# Rezoning Transportation Analysis

Petition Number: #2022-045

**From:** Jake Carpenter, PE

Date	Description
08-11-2022	First Review (WB)
09-21-2022	Second Review (JC)

SCHEMATIC SITE PLAN

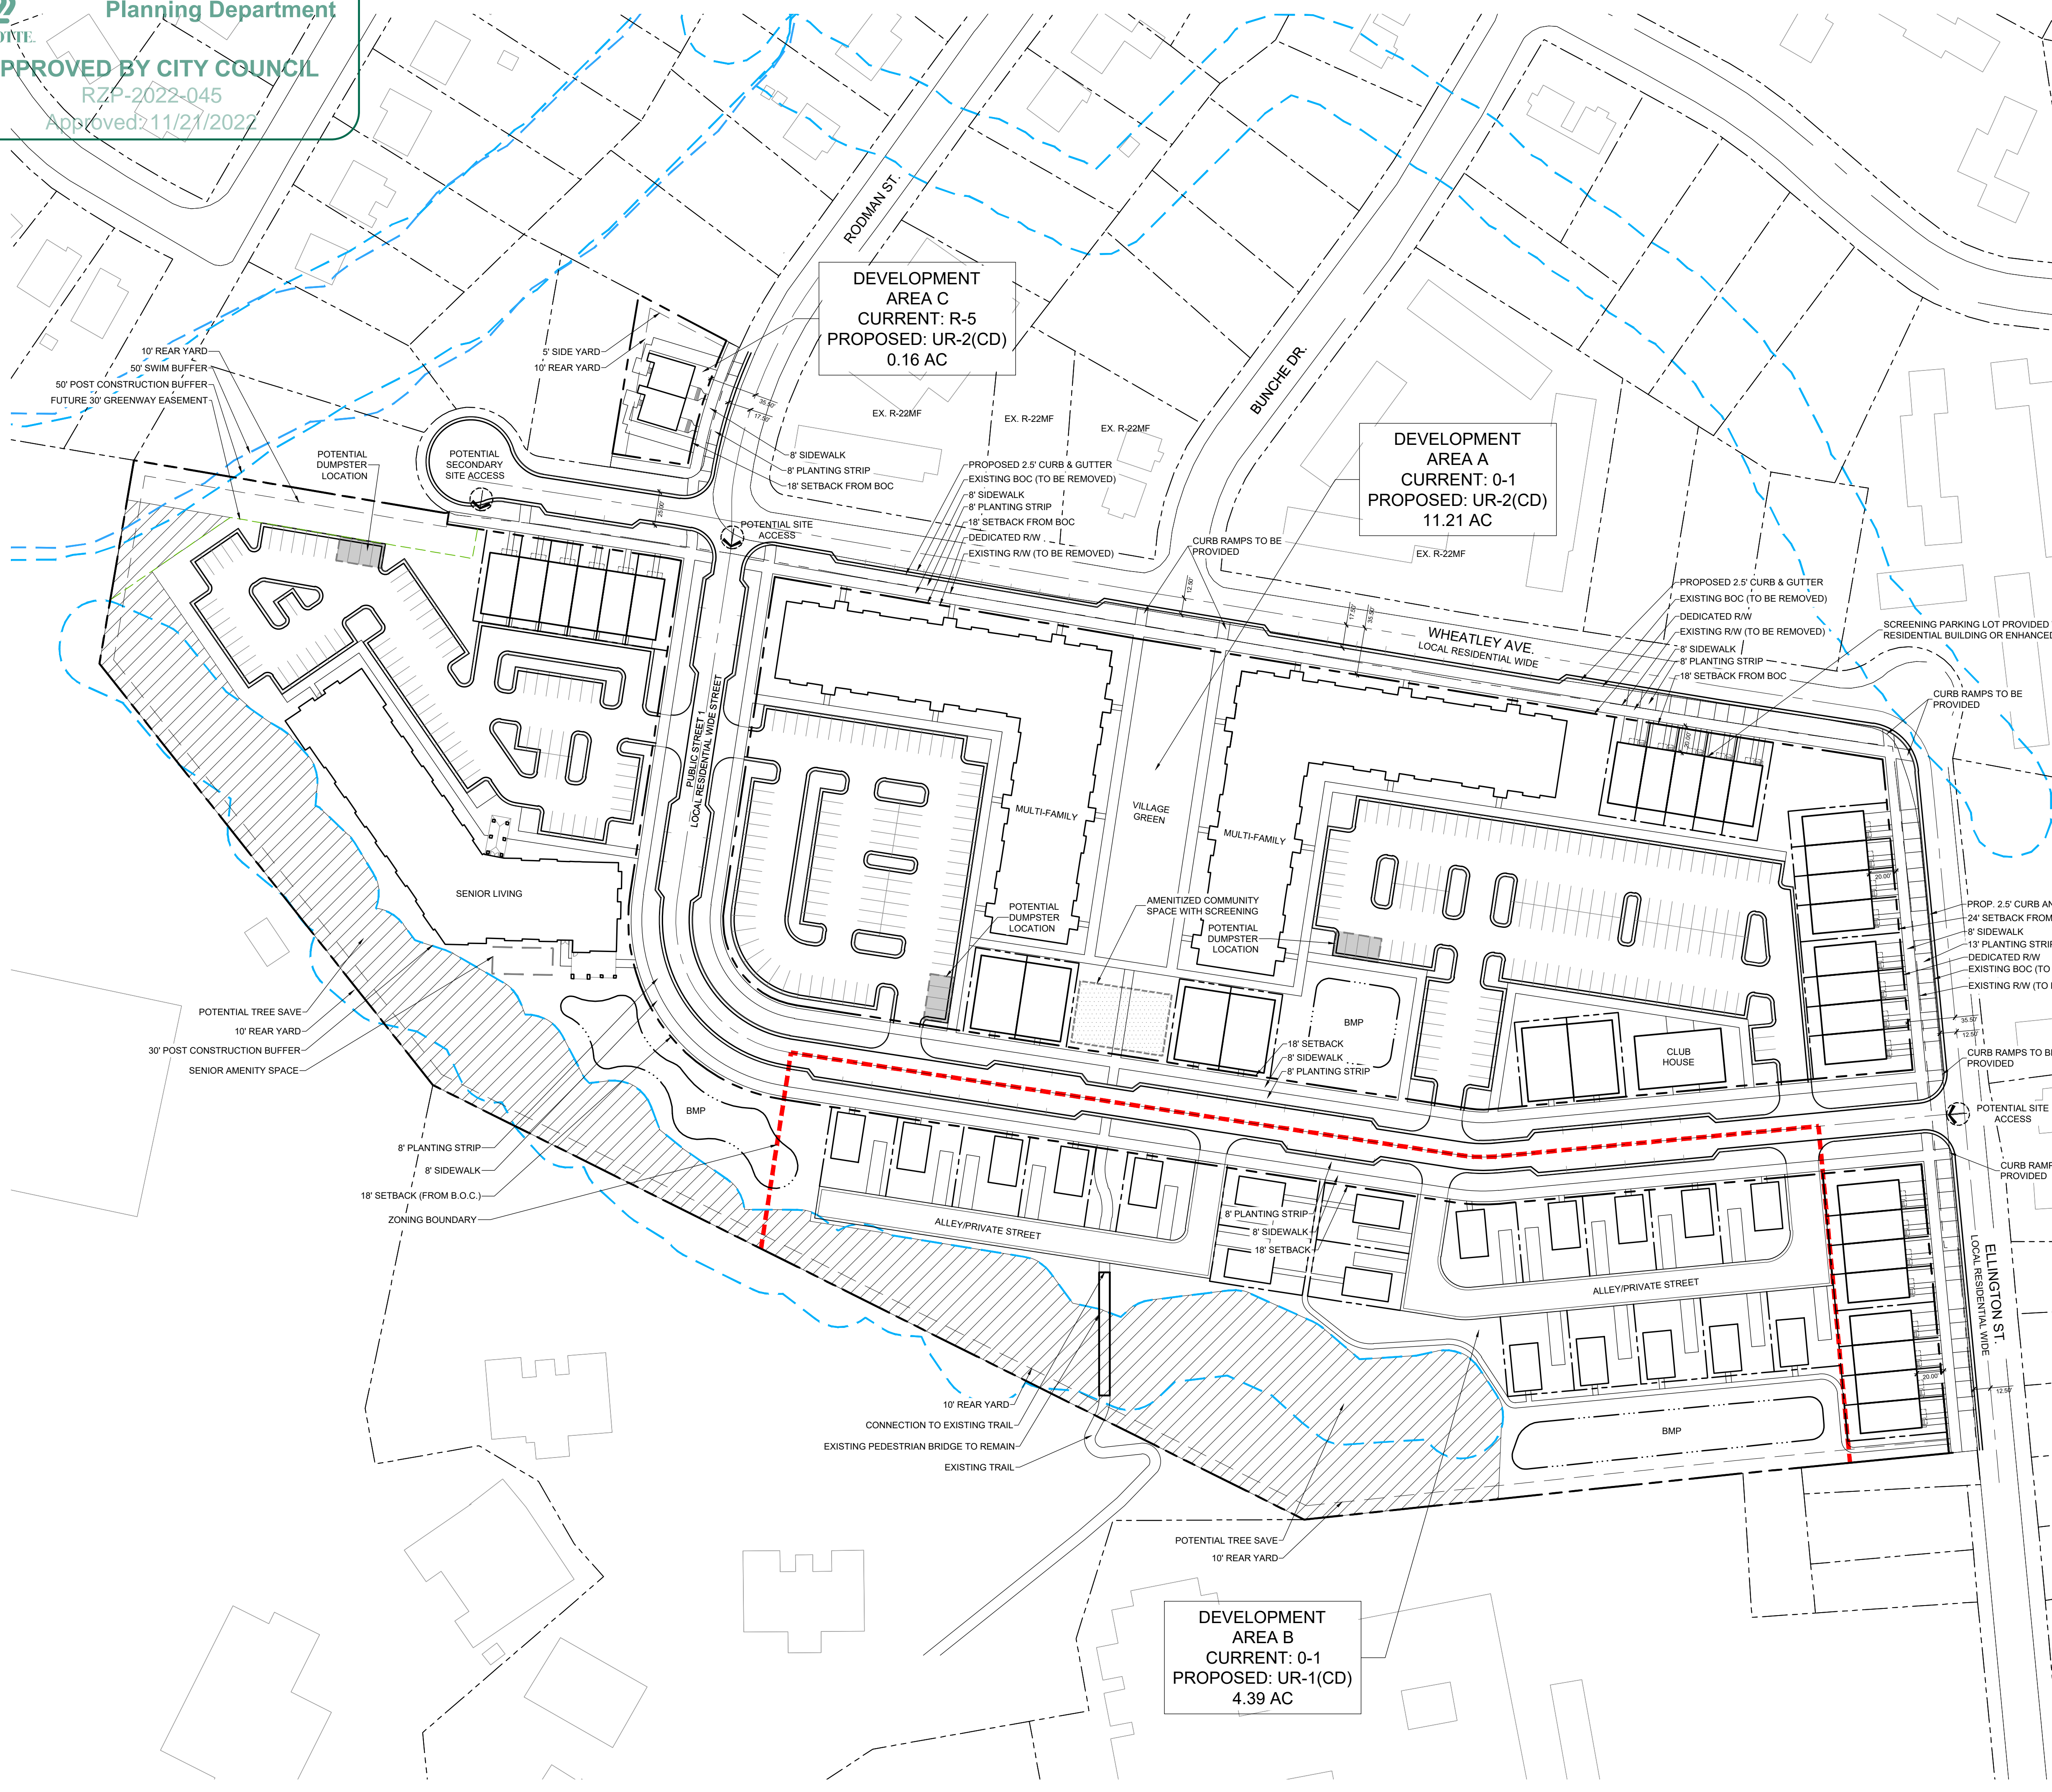
1. **Curbline:** The proposed zoning district has a setback measured from back of the existing or proposed future curbline.
  - a. **Wheatley Avenue:** The curb and gutter needs to be constructed 17.5-ft from the road centerline.
  - b. **Ellington Street:** ~~The curb and gutter needs to be constructed 20.5 ft from the road centerline.~~  
**Comment Update 09-21-22:** back of C&G to be constructed at 17.5-ft from road centerline except where driveways require utilization of CLDSM U-03C, where back of curb is to be located at 12.5-ft from road centerline.

~~Label and dimension the curb and gutter from the centerline for each road on the site plan.~~  
**Comment Update 09-21-22:** Label and dimension the curb and gutter from the centerline along Ellington St. where U-03C to be used.
2. **Traffic Study:**  
 A Traffic Impact Study (TIS) is not necessary for the complete review of this petition due to the site generating less than 2,500 daily trips. If during the permitting process the site generates more than 2,500 daily trips, then a traffic study will be required.
3. ~~Revise site plan and conditional notes to commit to dedicate 28.5 ft right-of-way from each public road centerline. The site plan shall label and dimension the right-of-way from each road centerline.~~

6. ~~Add site plan note specifying dedication and fee simple conveyance of all rights-of-way to the City before the site's first building certificate of occupancy is issued as needed. CDOT requests rights-of-way set at 2' behind back of sidewalk where feasible.~~
7. ~~Add a site plan note specifying that all transportation improvements will be approved and constructed before the site's first building certificate of occupancy is issued as needed. The petitioner may phase transportation improvements if said improvements and phasing are explicitly described in site plan notes.~~
8. **New Comment 09-21-22:** Remove conditional note 3f.

9. **New Comment 09-21-22:** Update conditional note 3h to call for dedication of 35.5' from center line.
